CITY OF ALBUQUERQUE

December 20, 2005

Re: Quality Jeep Chrysler, 9618 Eagle Ranch Rd NW
Grading and Drainage Plan
Engineer's Stamp dated 12-16-05 (C13-D28)

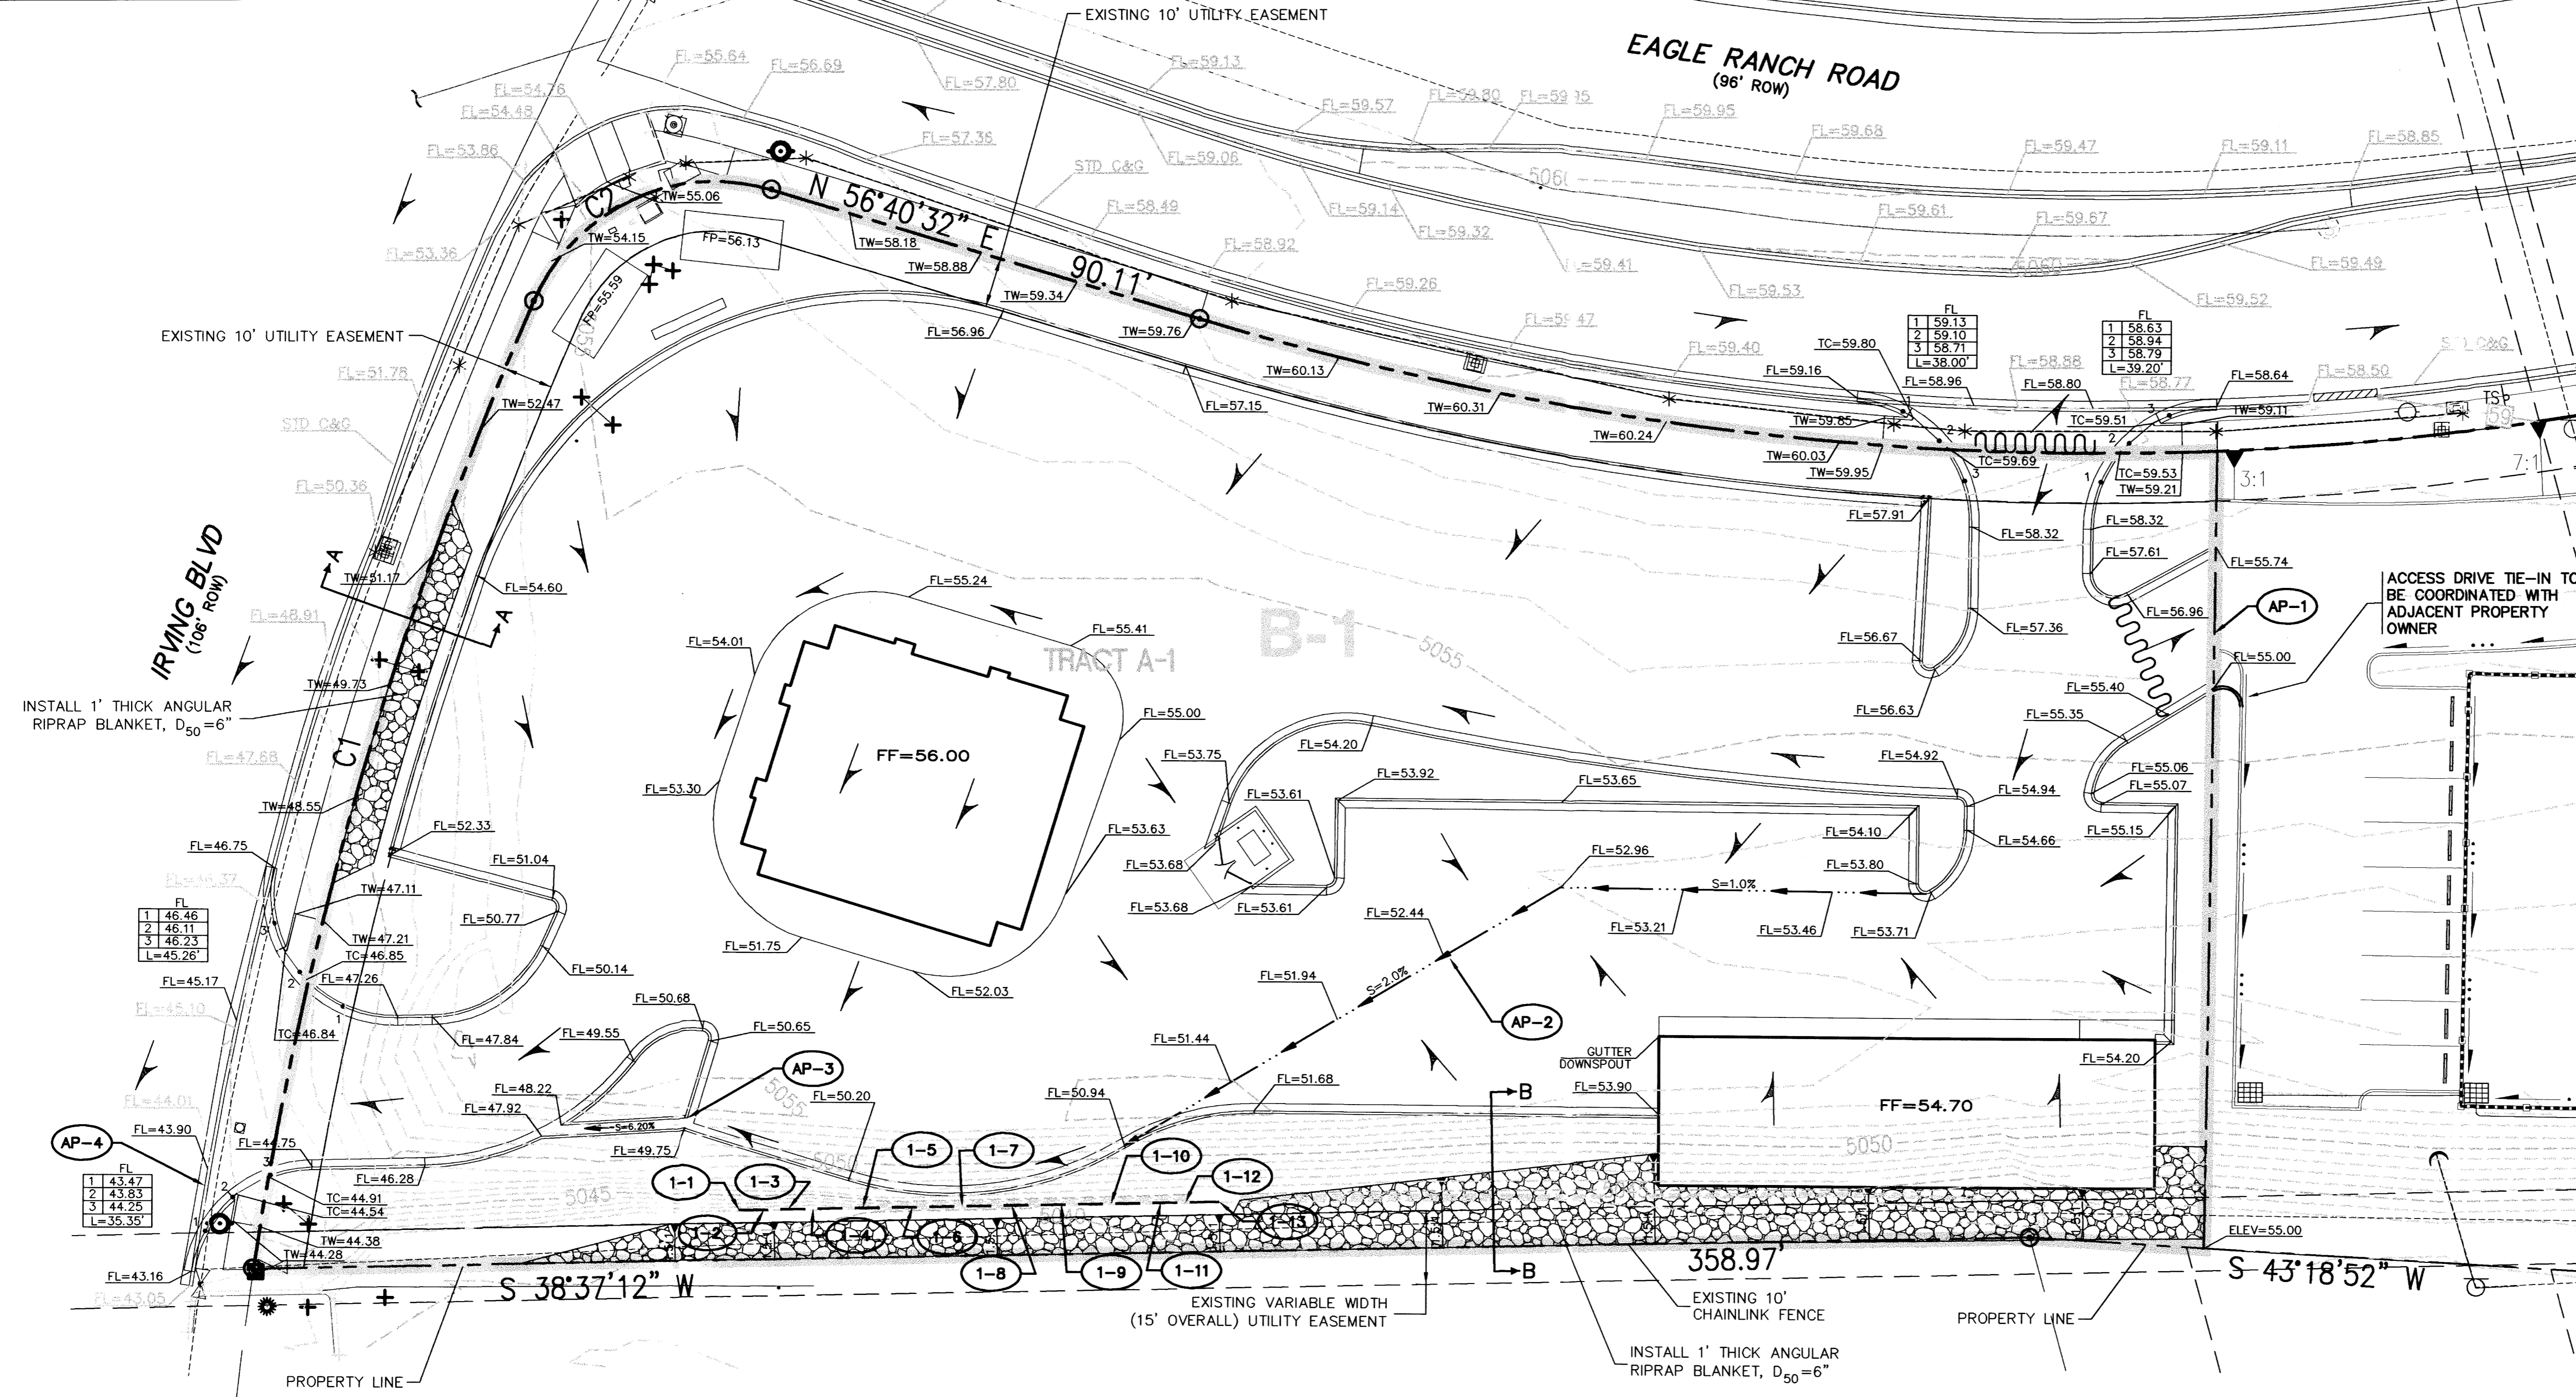
1. Call out the approved Master Drainage Plan or provide excerpts. What amount of sheet flow is allowed to leave this site?
2. What precipitation zone was used for your analysis?
3. Building on SE corner of site must drain toward parking lot. Please verify this is the situation.
4. It appears there may be an existing inlet at your Irving drive. Please verify location of this inlet.

Based upon the information provided in your submittal received 12-16-05, the above referenced plan is approved for Building Permit and Grading Permit.
